**From:** Laura Gibbons [REDACTED]  
**Sent:** 20 April 2021 09:16  
**To:** Anita Gardner <Anita.Gardner@arun.gov.uk>  
**Cc:** Planning.Responses <Planning.Responses@arun.gov.uk>  
**Subject:** Re: FW: Planning Consultation on: CM/11/21/DOC

**Application No:** CM/11/21/DOC  
**Registered:** 5th March 2021  
**Site Address:** Scyld Horsemere Green Lane Climping BN17 5QZ  
**Description of Works:** Approval of details reserved by condition imposed under CM/21/19/PL relating to conditions 11-surface water drainage scheme, 12-discharge of flows to water courses or for the culverting, diversion, infilling or obstruction of any water course on or adjacent to site & 13-maintenance and management of surface water drainage system.

DRAINAGE GA

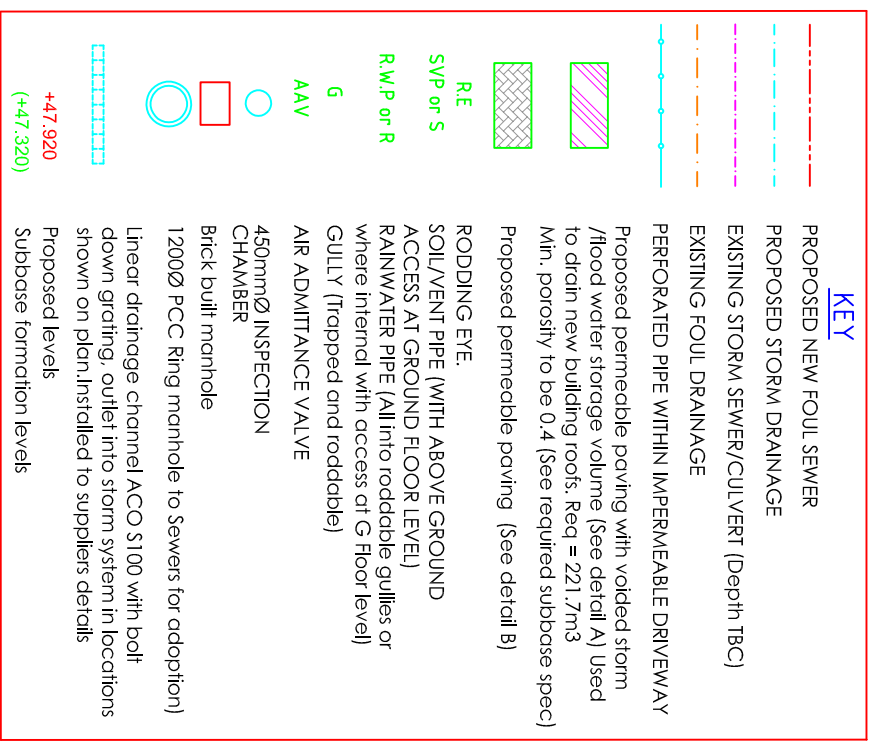
4. Please detail finish and formation levels of permeable paving on plan. These are shown in the detailed sections but have also been added to the plan. *Please detail on driveways.*

6. Please detail all pipe diameters and falls on plan. Plan updated. *Please detail pipes in permeable paving driveways.*
7. No connections are shown to/ from the permeable car park areas. We have now shown a connection into the storm drainage system.

DETAIL 1: TYPICAL SECTION SHOWING NEW ENTRANCE AND EXISTING HIGHWAY WITH NEW CULVERT

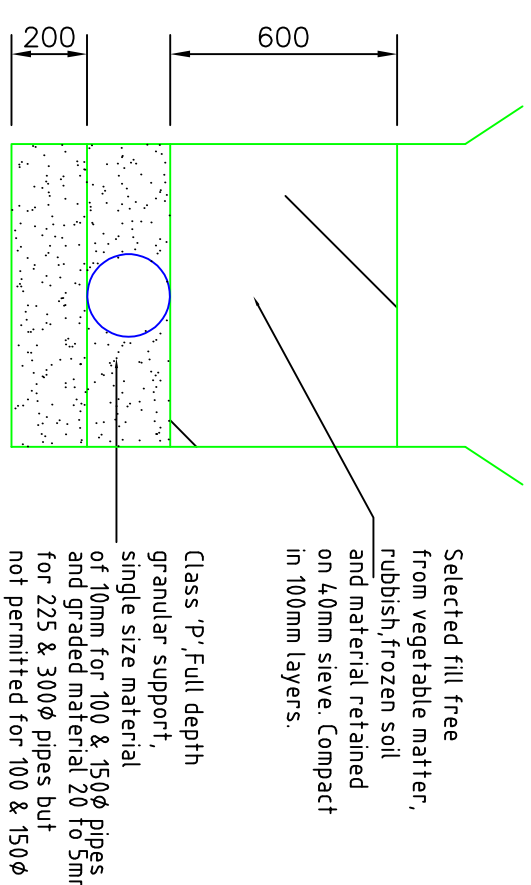
1. Please supply further details of the proposed culvert, i.e. diameter, invert level, and construction details-including headwalls. *We have put more information on the drawing on the details drawing. Two sets of drainage details sheet 2 have been provided, please confirm which version should be reviewed.*
2. It is stated on the plans that the culverting has been agreed, we do not believe this to be the case. Please supply evidence that an application for land drainage consent has been made for both the proposed culverting and outfall headwall. This has been applied for and we are issuing new information and the application is ongoing. *Okay.*

HEADWALL STRUCTURE FOR OUTLET PIPE

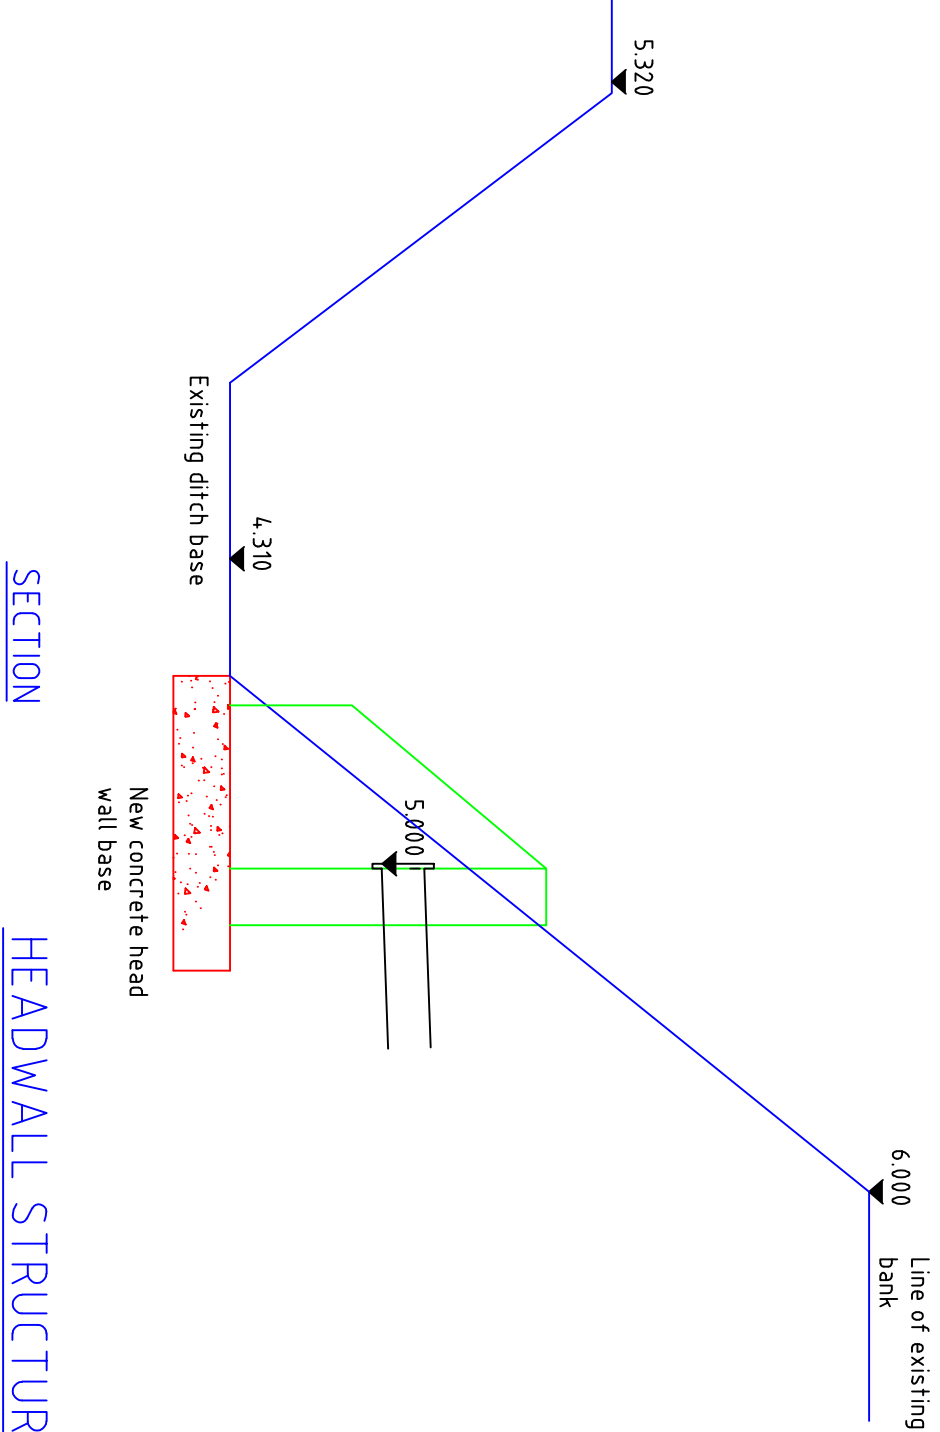
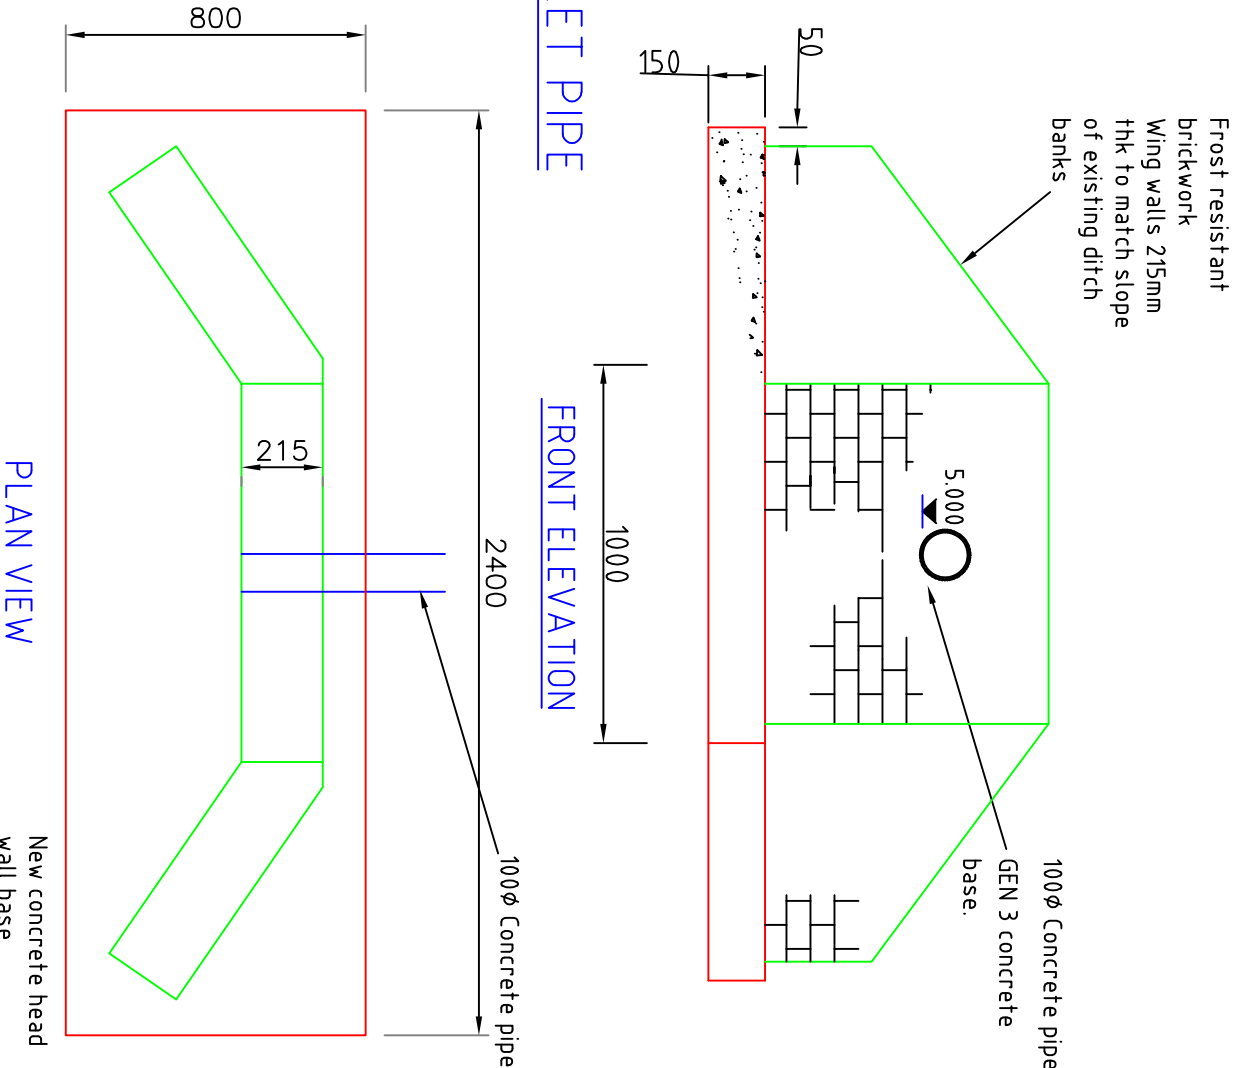
bank level. Detail updated. *Two sets of drainage details sheet 2 have been provided, please confirm which version should be reviewed.*
